Recommendation Report for Planning Permission

REF NO: R/138/20/PL

LOCATION: 55 Milton Avenue
Rustington
BN16 2PL

PROPOSAL: Demolition of garage & construction of 1 No. 2-storey chalet dwelling (resubmission following R/182/18/PL).

**Proposed Floor Plans
and Roof Plan**

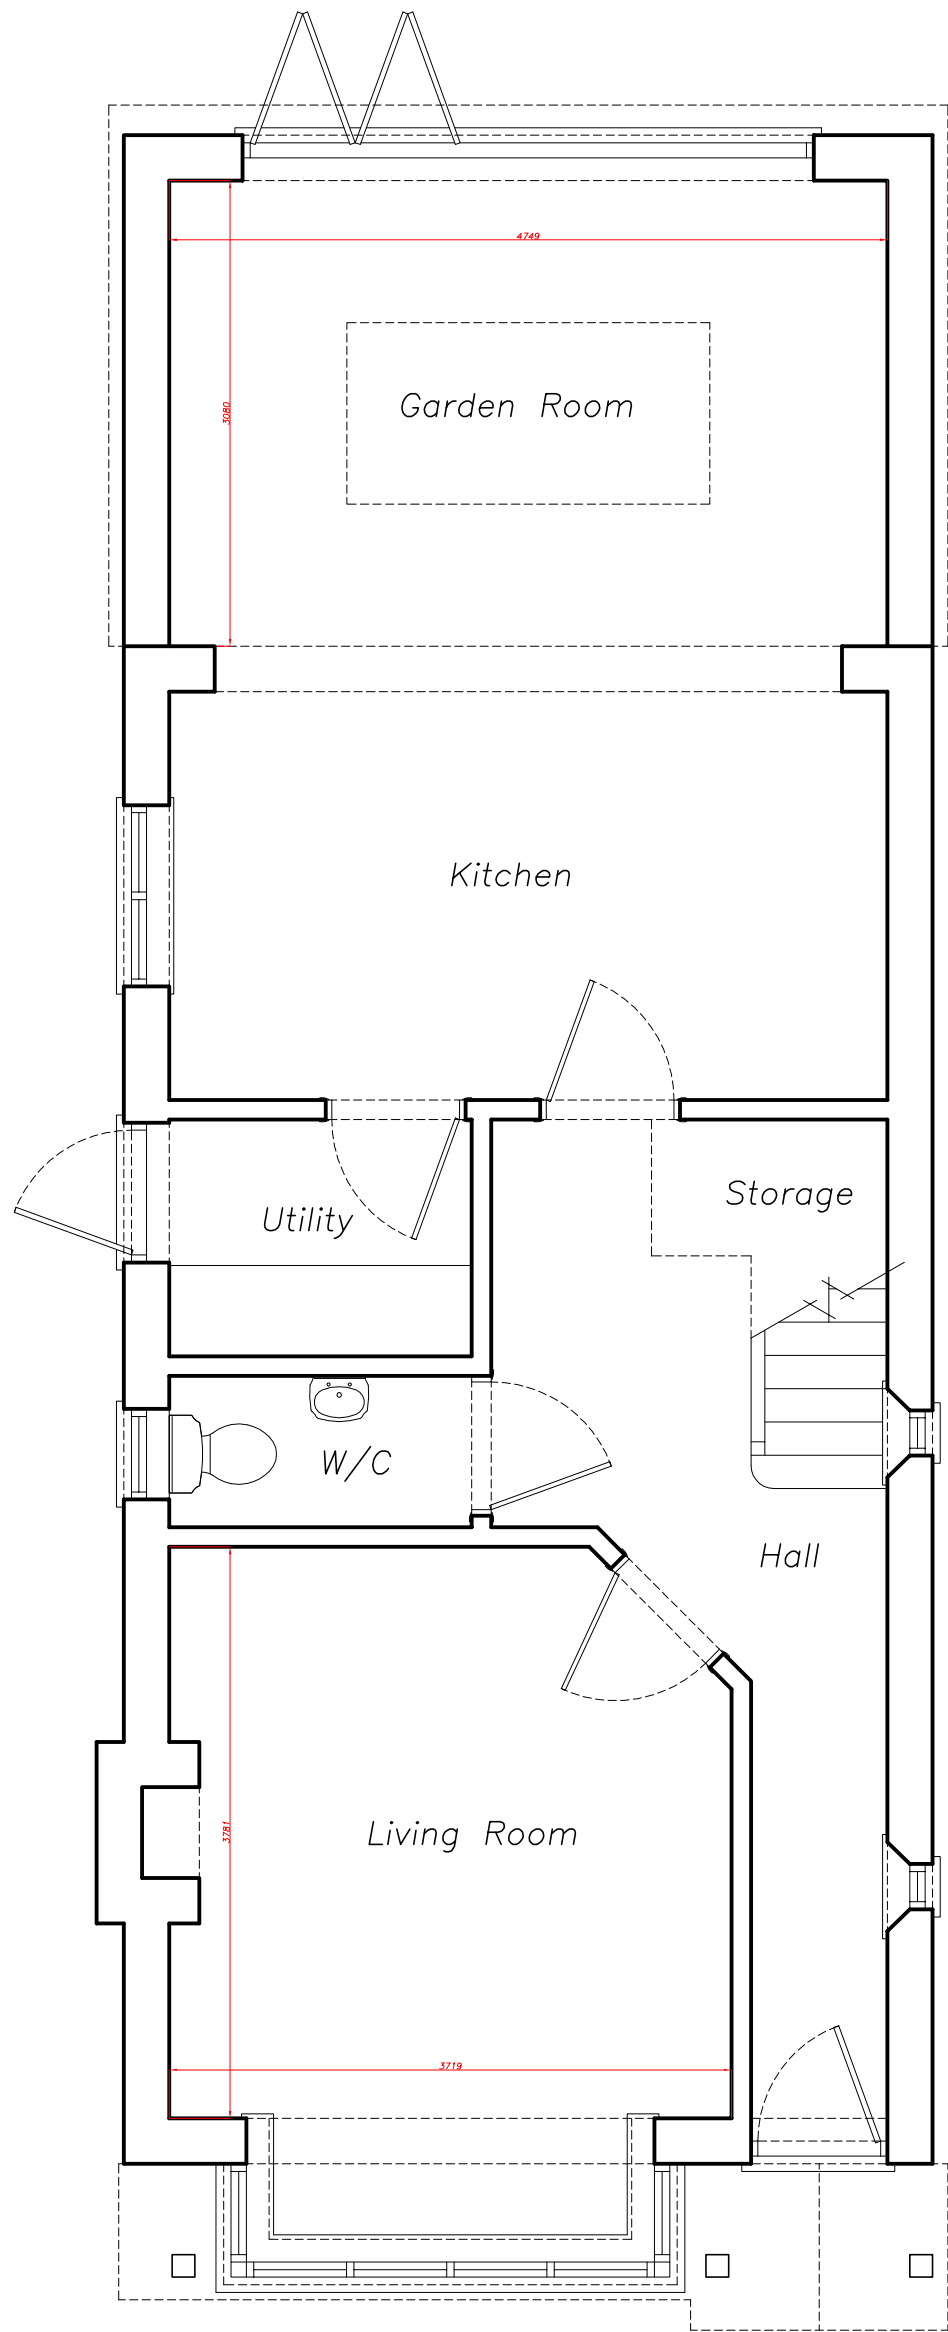
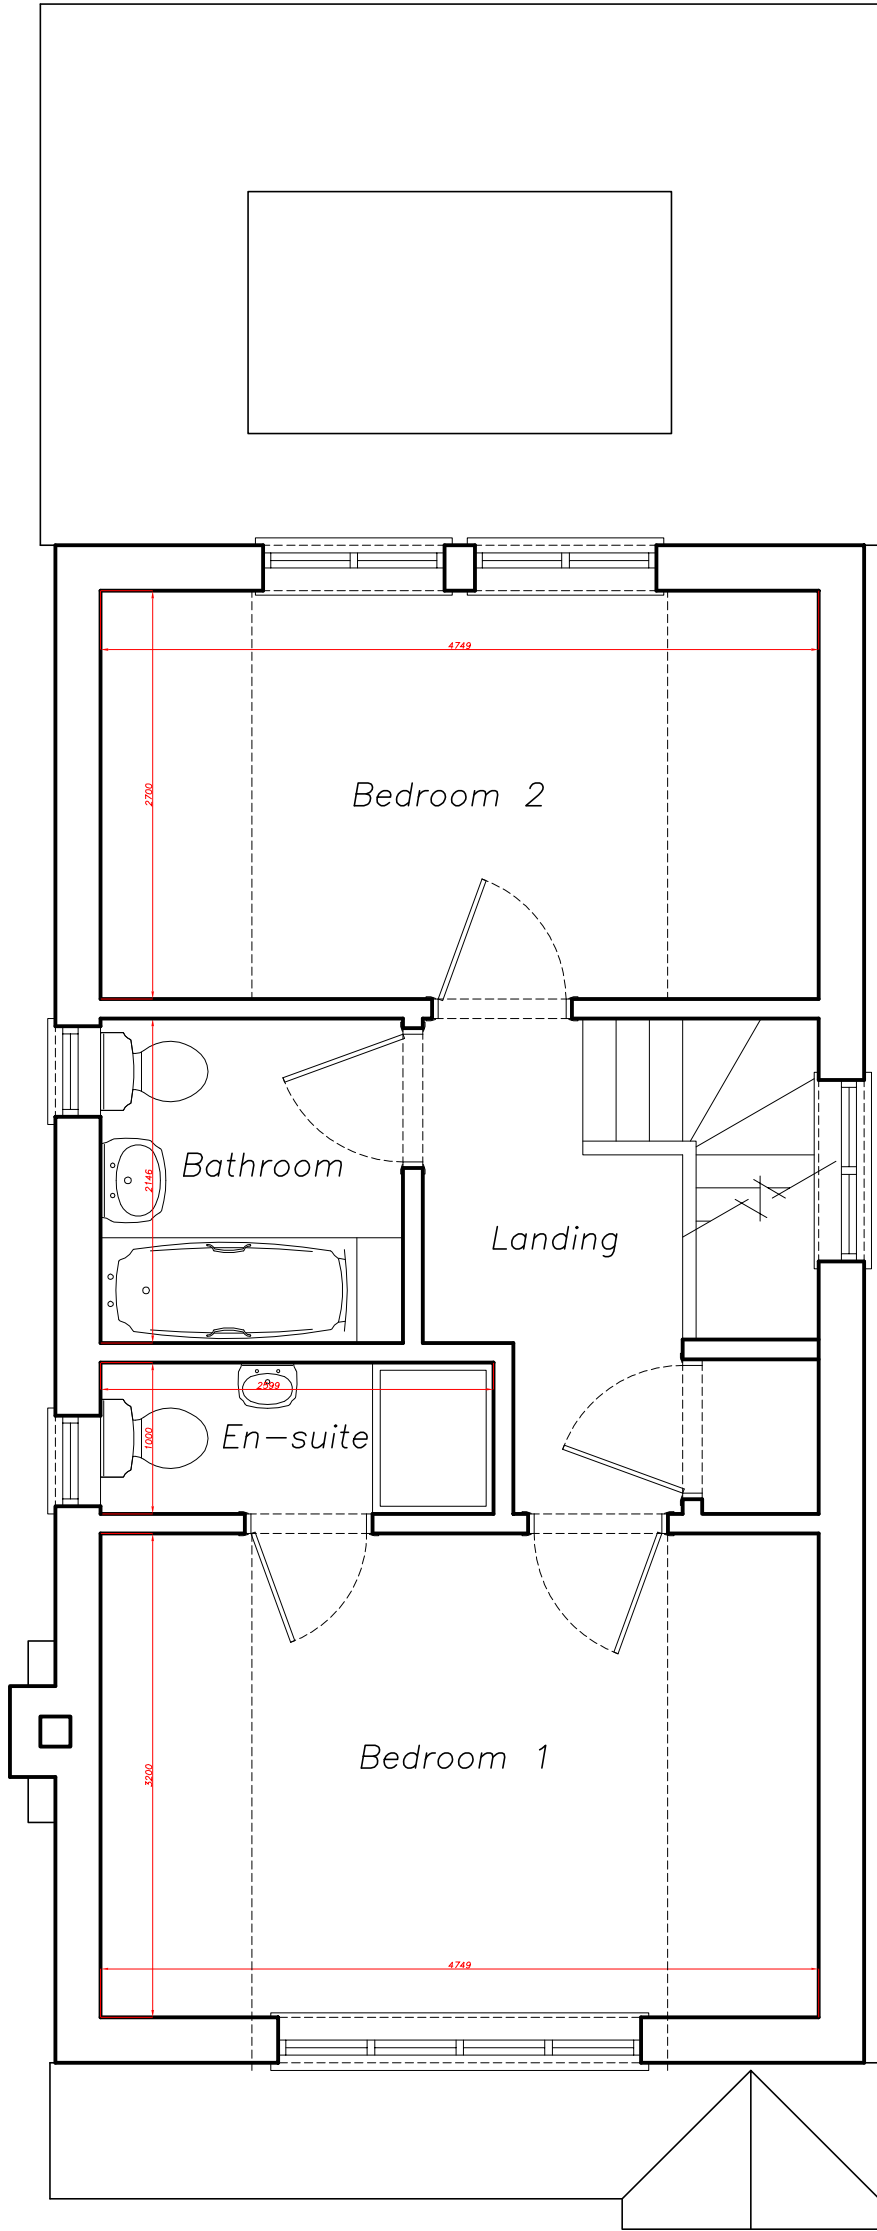
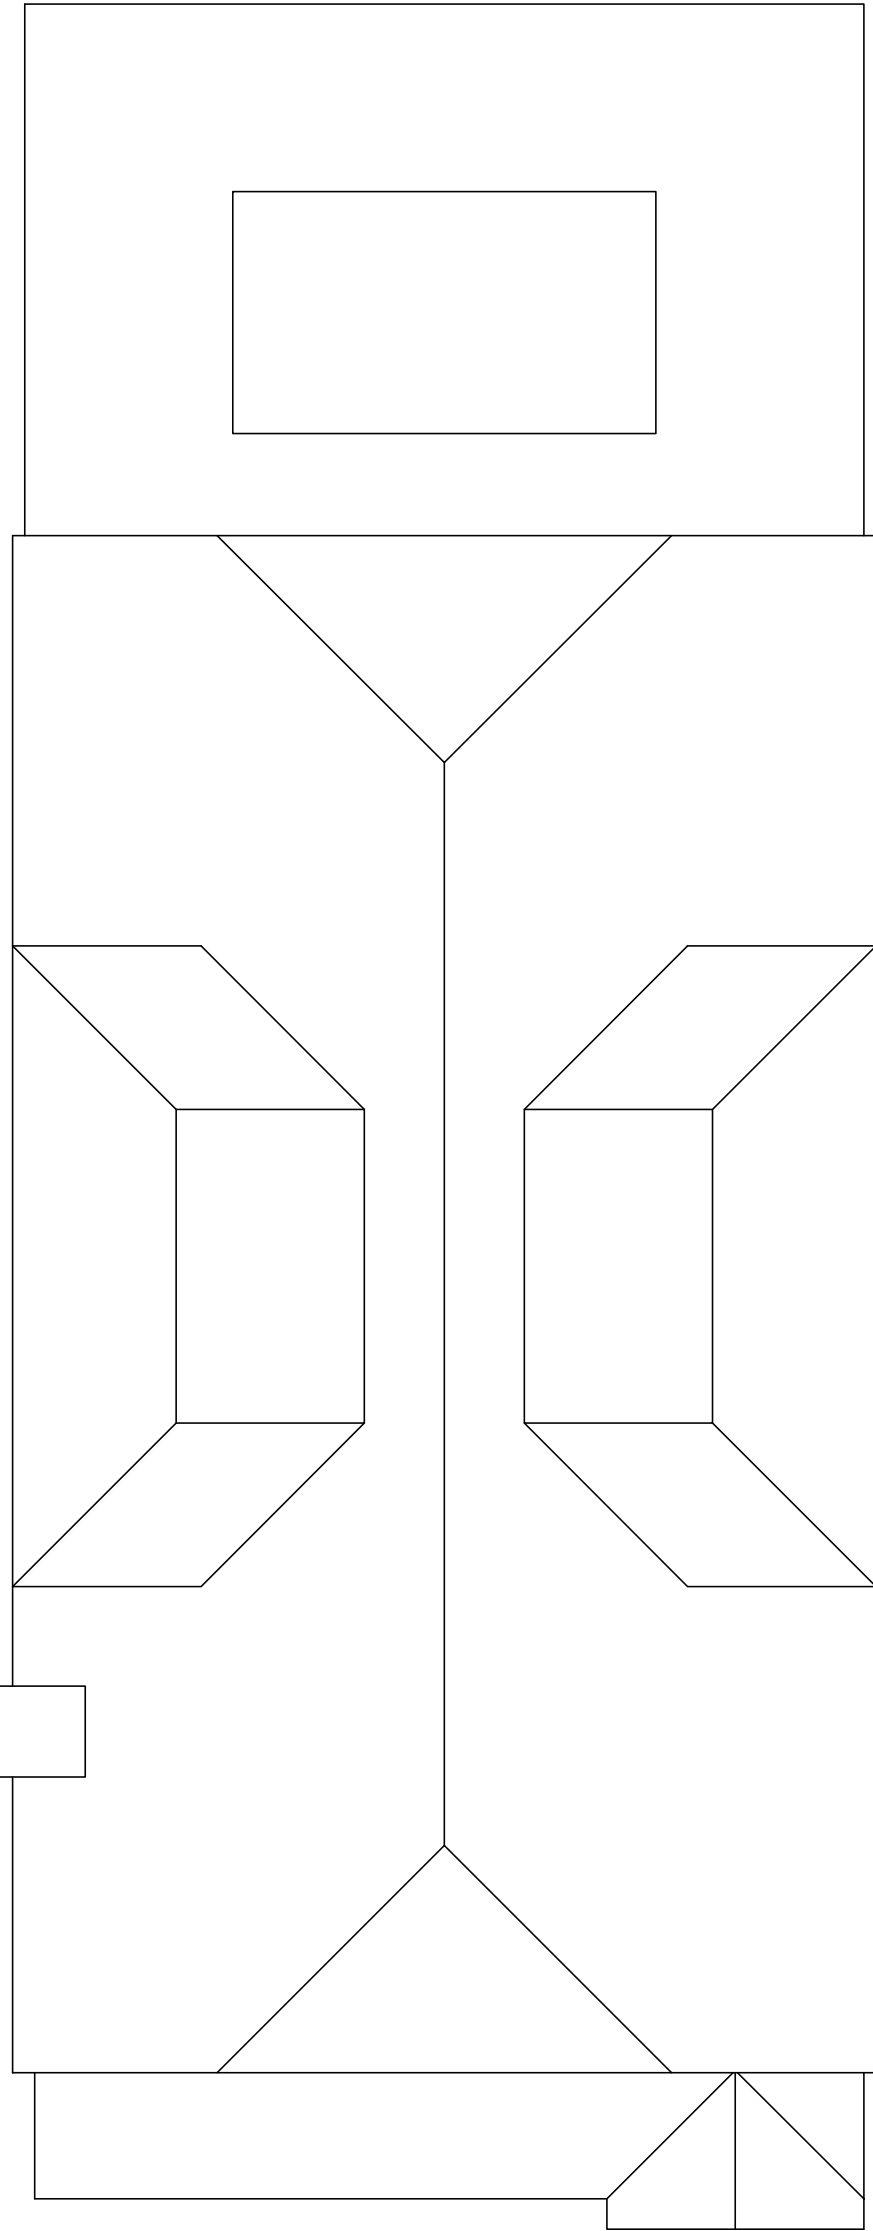
There is no considered loss of privacy to neighbouring properties as the design provide for windows serving the west and east elevations fronting the highway and the rear garden respectively. The north elevation would have a first floor window to serve a bathroom (which could be conditioned to be obscure glazed and fixed shut) whilst south elevation windows would provide light to the stairwells.
